4 December 2019

**RESPONSE TO SUBMISSIONS – EASTLAKES SHOPPING CENTRE  
GARDENERS ROAD, EASTLAKES  
MP09\_0146 MOD 4**

Reference is made to the Department's correspondence dated 22 November 2019, regarding the Response to Submissions (RtS) which was referred to the former Roads and Maritime Services (Roads and Maritime) now Transport for NSW (TfNSW) for comment. On 1 December 2019 legislation came into effect to bring Roads and Maritime and TfNSW together as one organisation.

**Base Case Thursday morning
peak hour traffic flows plus
development traffic
Figure 3**

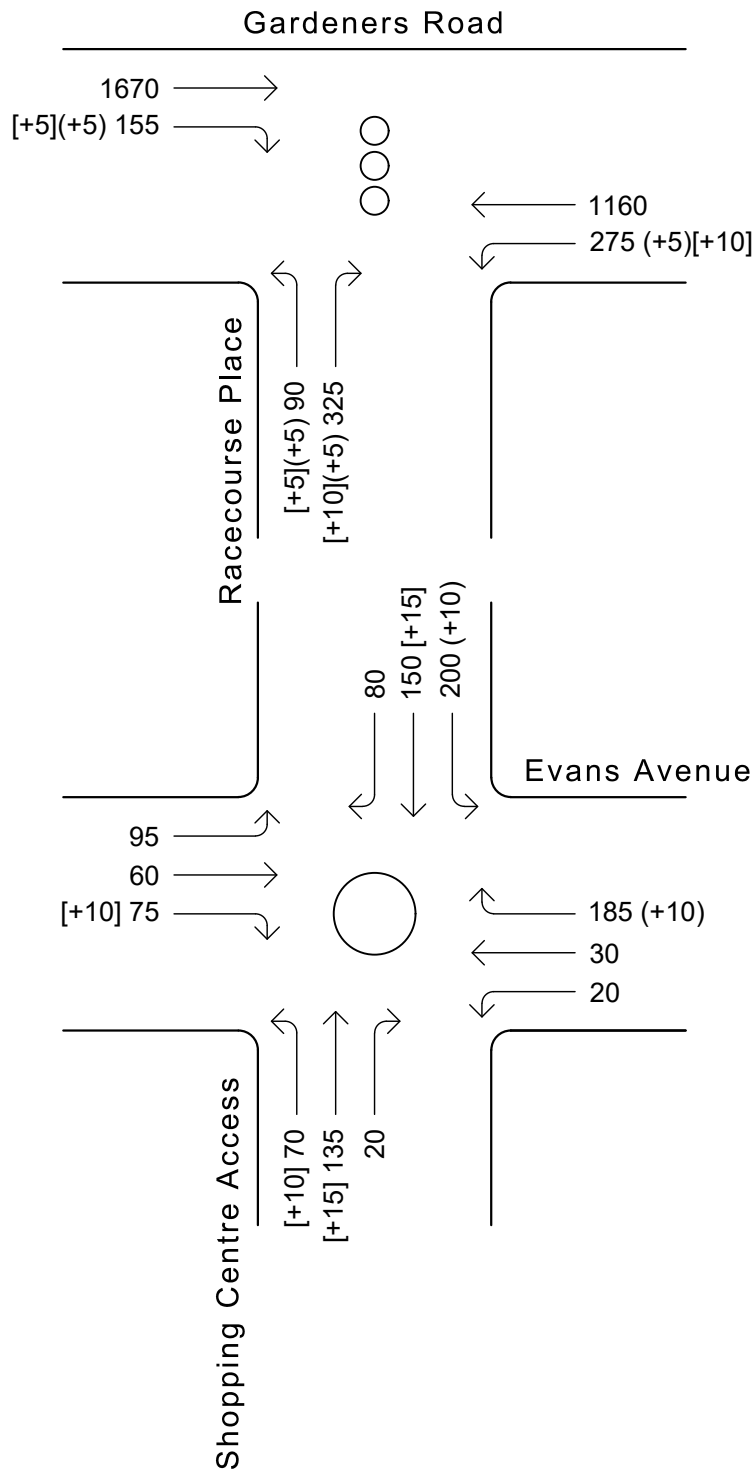
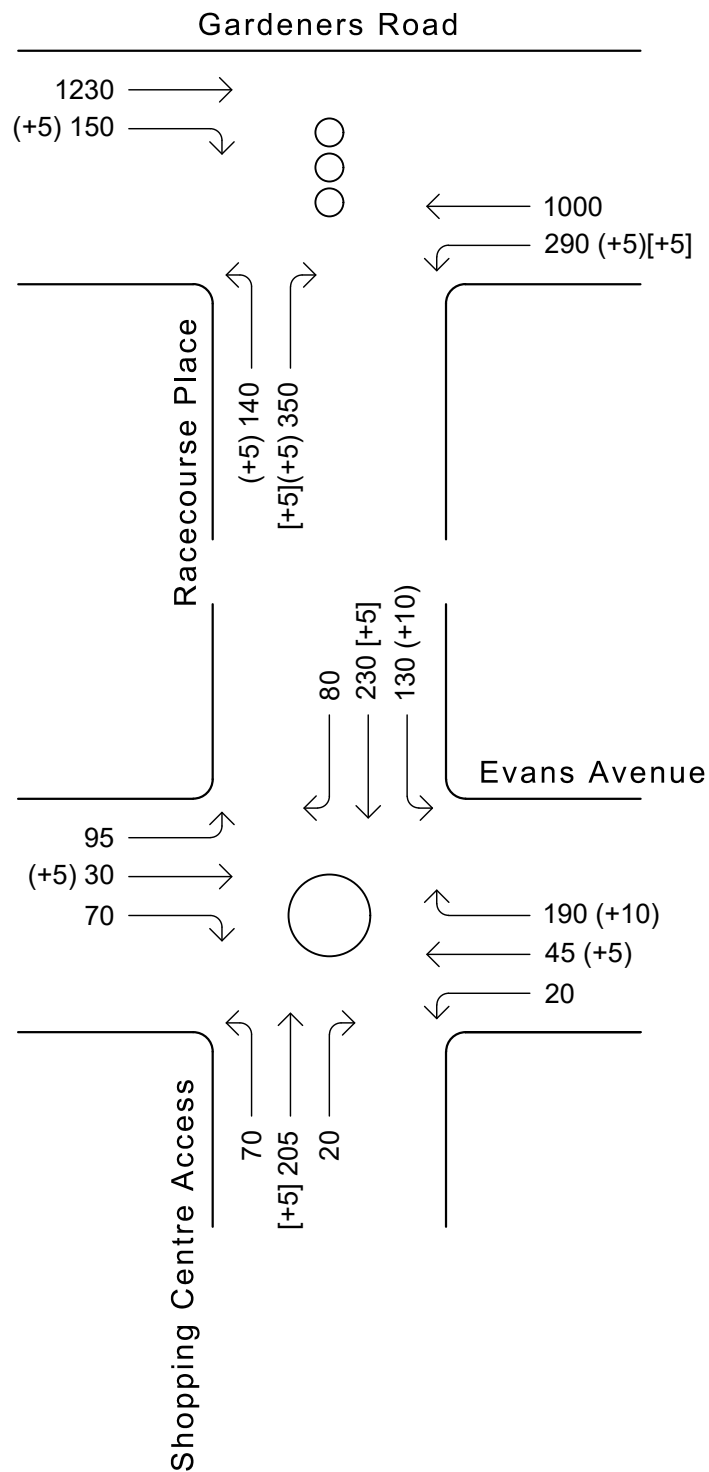
1. Modelling indicates that with the proposed modifications, there will be a negative impact to the future performance of the Gardeners Road/Racecourse Place intersection. The modelling provided in the RtS suggests that the right turn lane from Gardeners Road into Racecourse Place will be beyond capacity causing safety and efficiency concerns for Gardeners Road, which is a classified state road. This is particularly evident during Saturday peak periods.

TfNSW recommends that the proponent review the modelling and propose appropriate mitigation measures to ensure that the modification does not compromise the safety and efficiency of Gardeners Road.
